## DRB CASE ACTION LOG - BLUE SHEET

Project #: 1009234 Application #: 13DRB-70460  
Project Name: St. Joseph Hospital Complex  
Agent: The Design Group Phone #:

Sheet Number:
LS-01

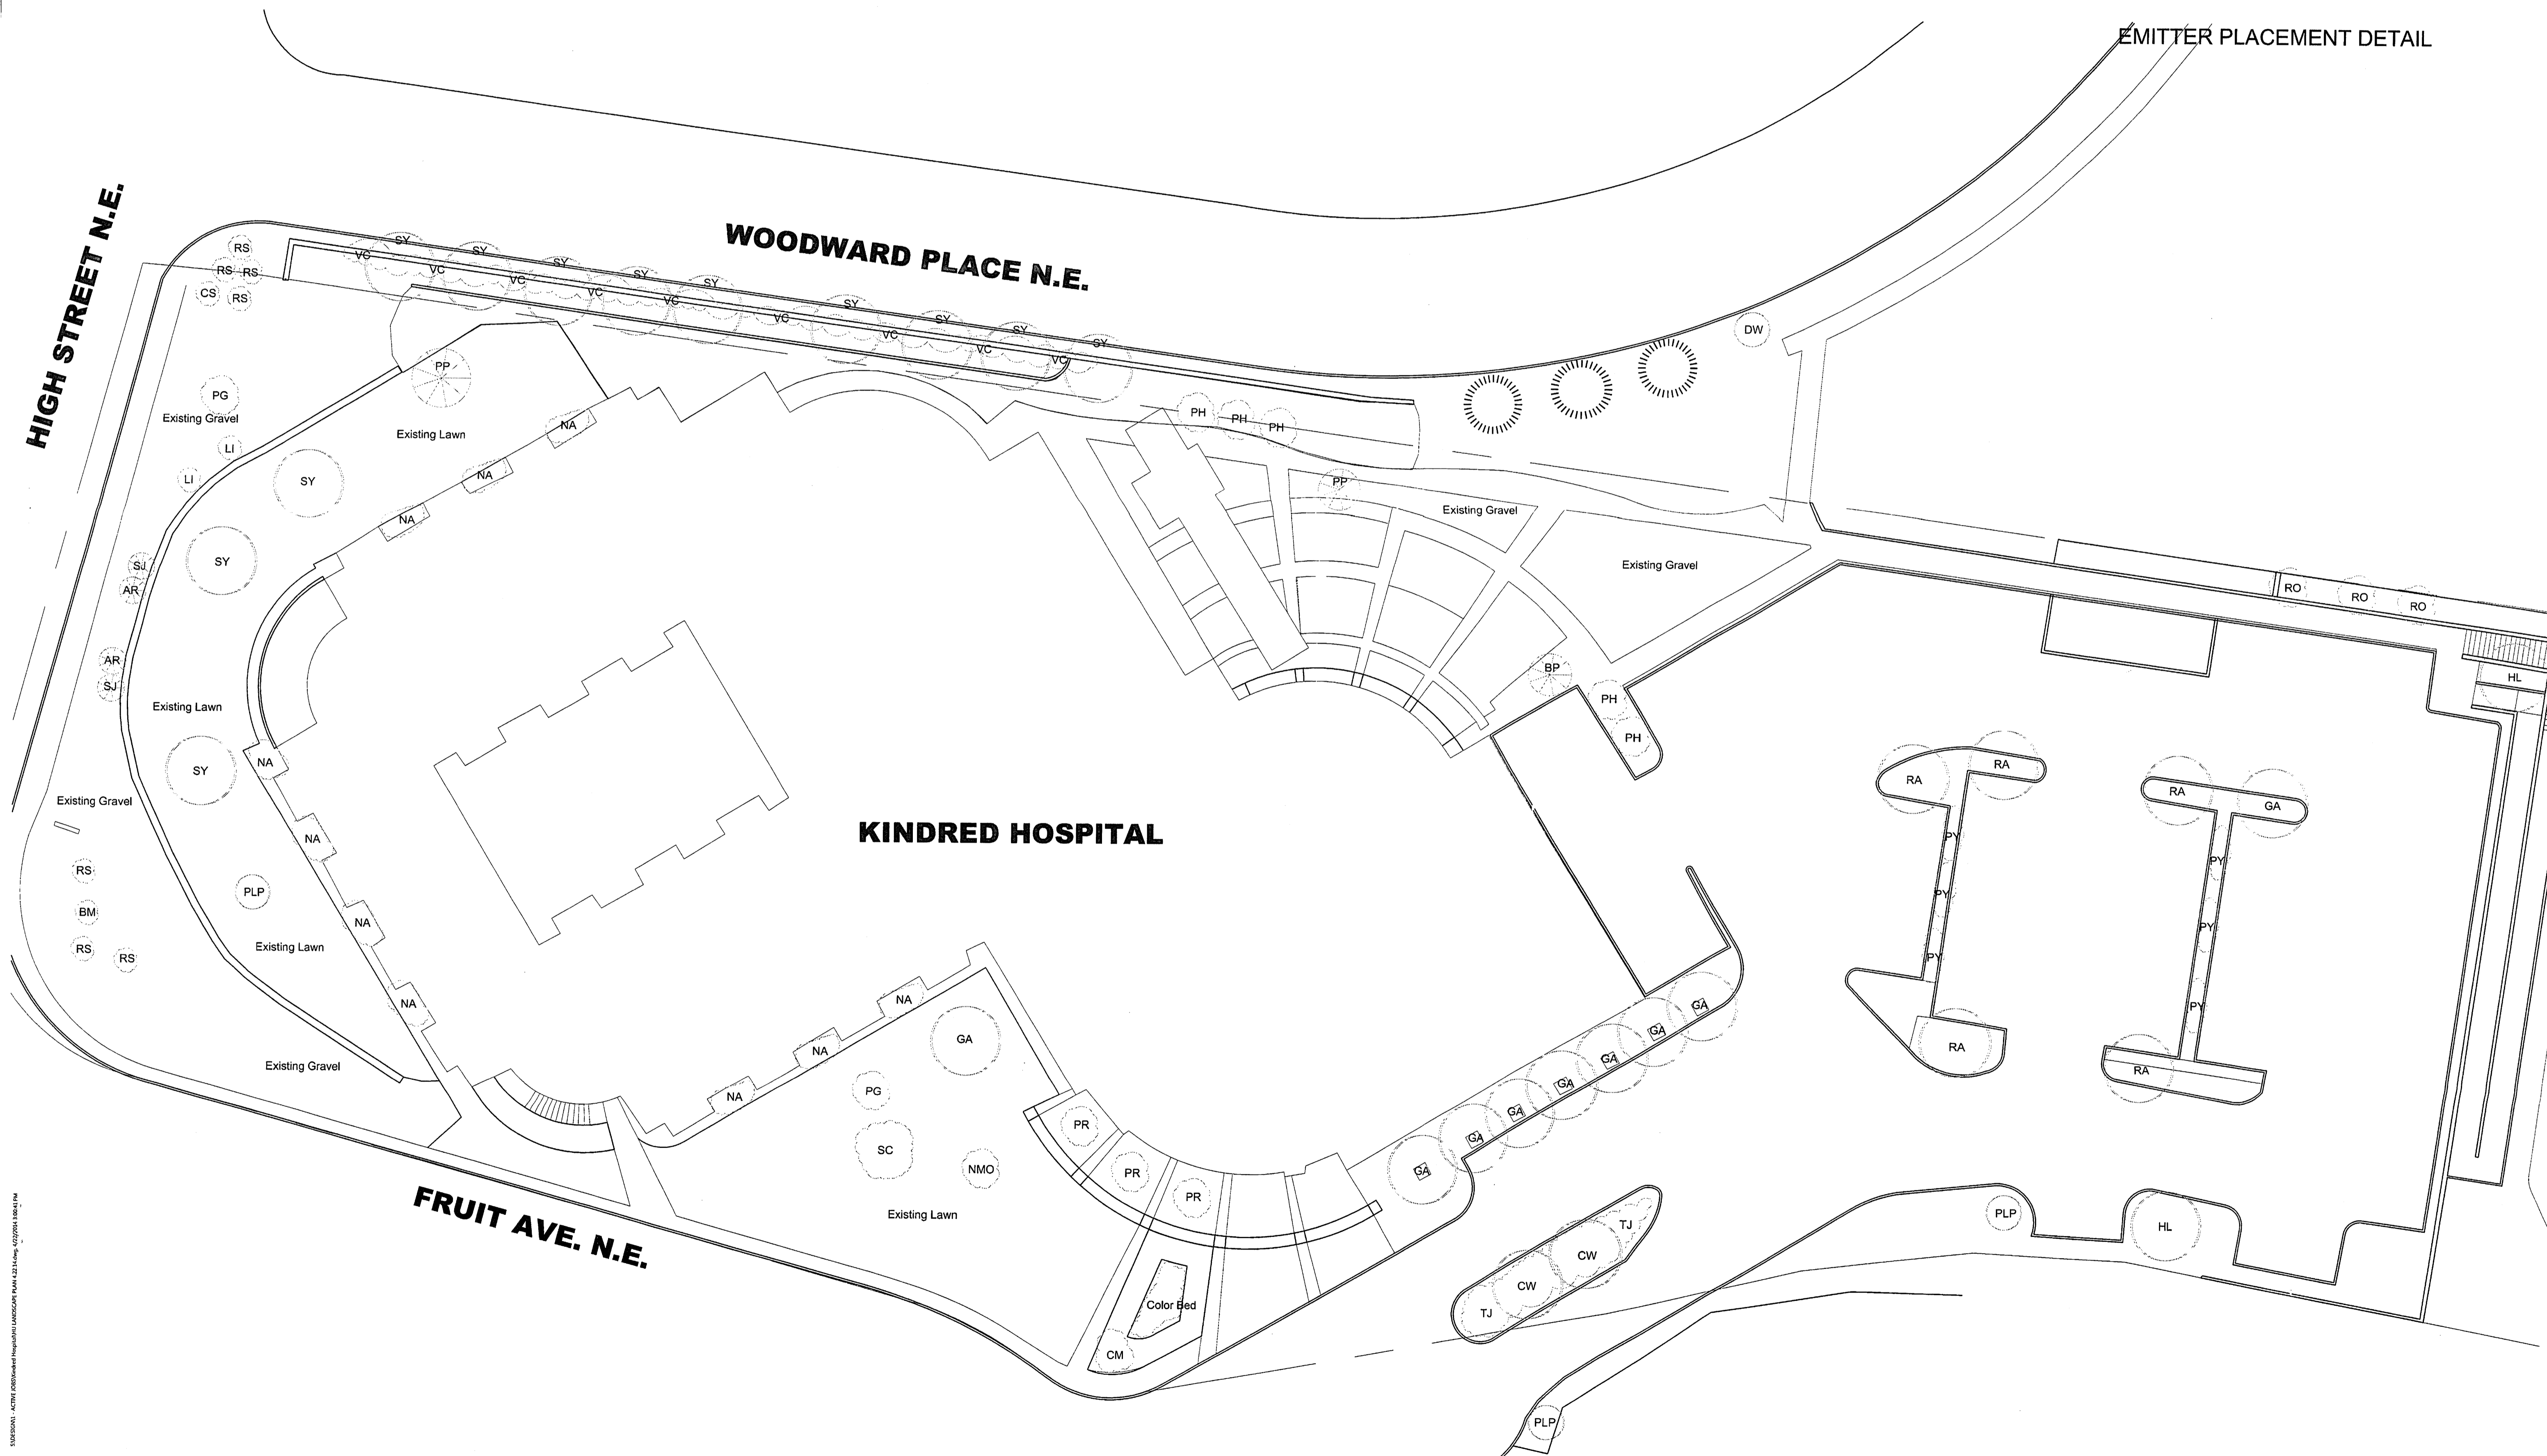
- ☐ TRANSPORTATION:
- ☐ ABCWUA:
- ☐ CITY ENGINEER / AMAFCA:
- ☒ PARKS / CIP: retable landscaping on north
- ☒ PLANNING (Last to sign):
